From: Downes, Scott G (DFW) <Scott.Downes@dfw.wa.gov>
Sent: Thursday, December 10, 2020 1:08 PM
To: Kelly Bacon (CD) <kelly.bacon.cd@co.kittitas.wa.us>
Cc: Torrey, Elizabeth M (DFW) <Elizabeth.Torrey@dfw.wa.gov>; Jeremy Johnston <jeremy.johnston@co.kittitas.wa.us>
Subject: RE: Notice of Application SE-20-00009 Kittitas County Ryegrass Facility

Subject: Notice of Application SE-20-00009 Kittitas County Ryegrass Facility

Ryegrass Application Fields

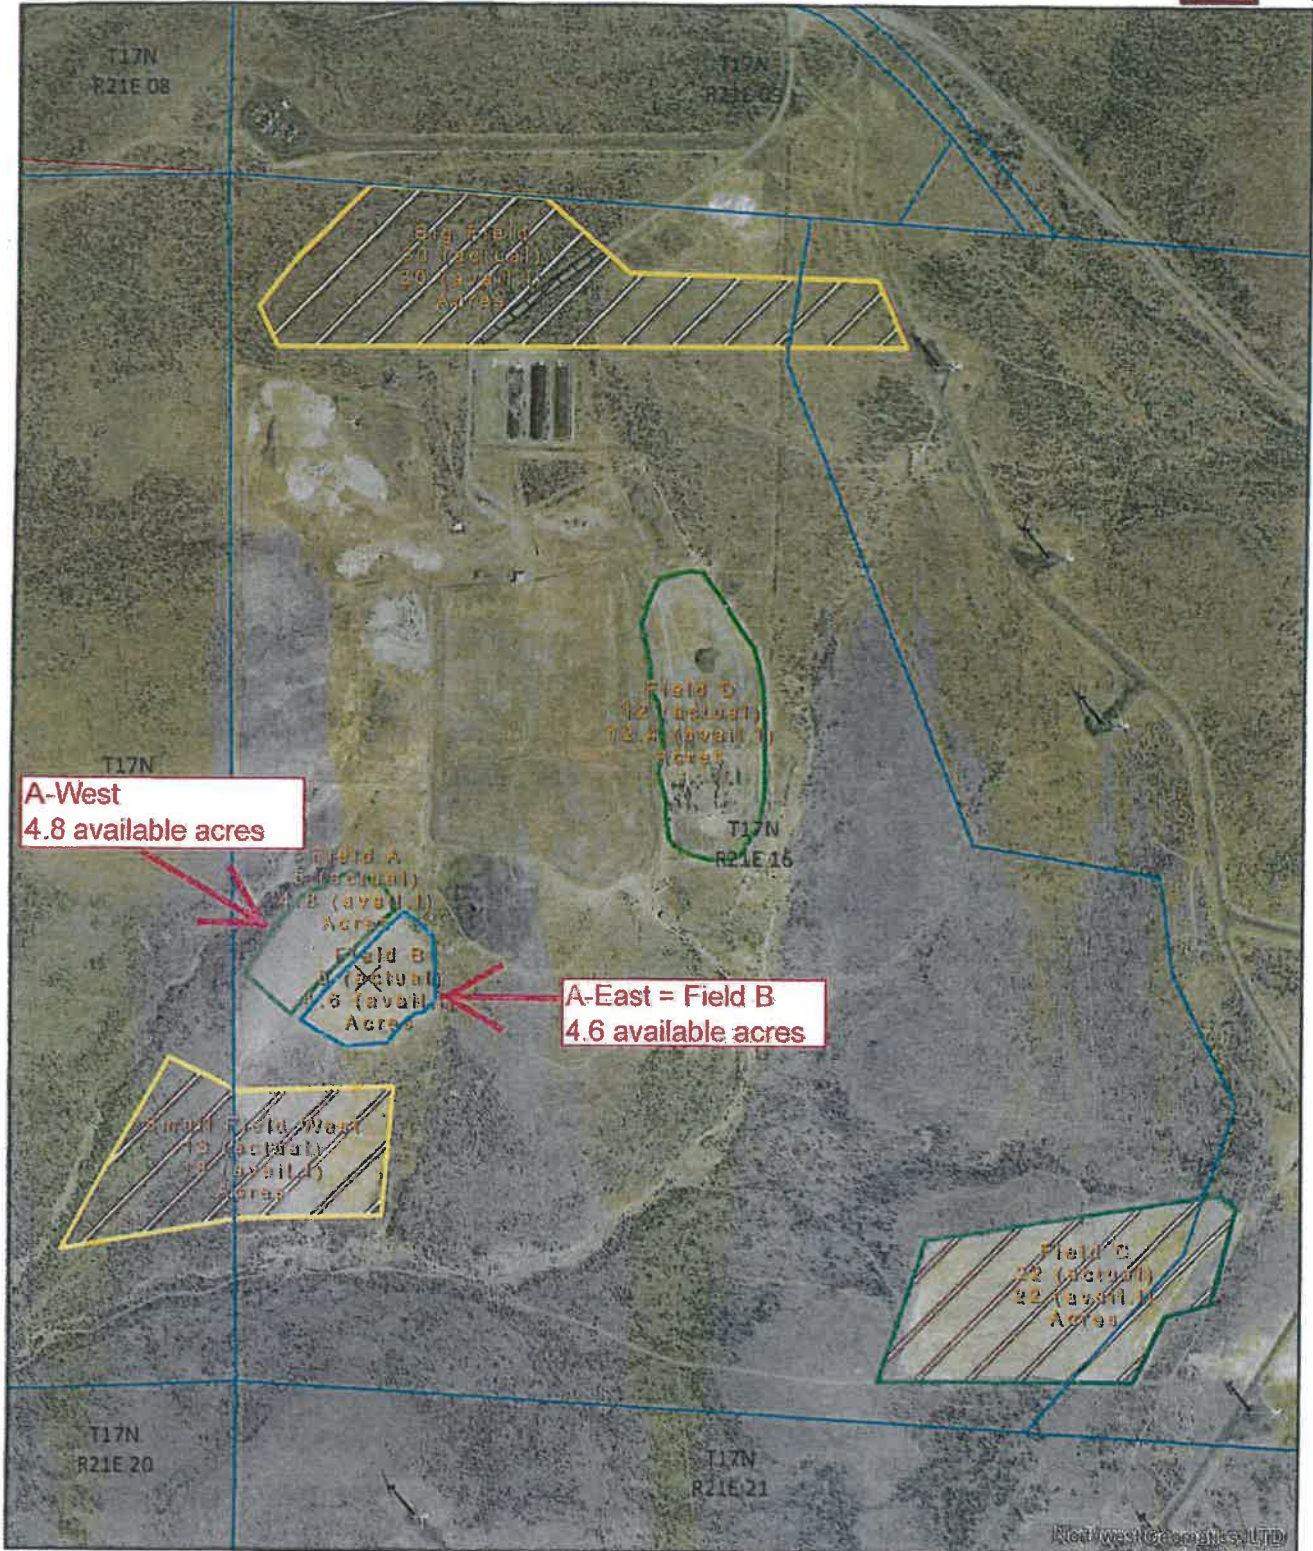
1. In between the application areas, there is sagebrush areas, which is a diminishing and priority habitat in the county. WDFW would like to see no new clearing of sagebrush in this area (so application limited to already cleared areas). If additional clearing must occur, then consulting with WDFW for mitigation to clearing would be encouraged.
2. When these fields were originally cleared, they likely contained sagebrush as evidenced by the surrounding areas containing sagebrush. When the fields are no longer desired to be used for this biosolid treatment, WDFW would recommend that sagebrush would be planted as part of a restoration plan as that would help to improve habitat in the area.
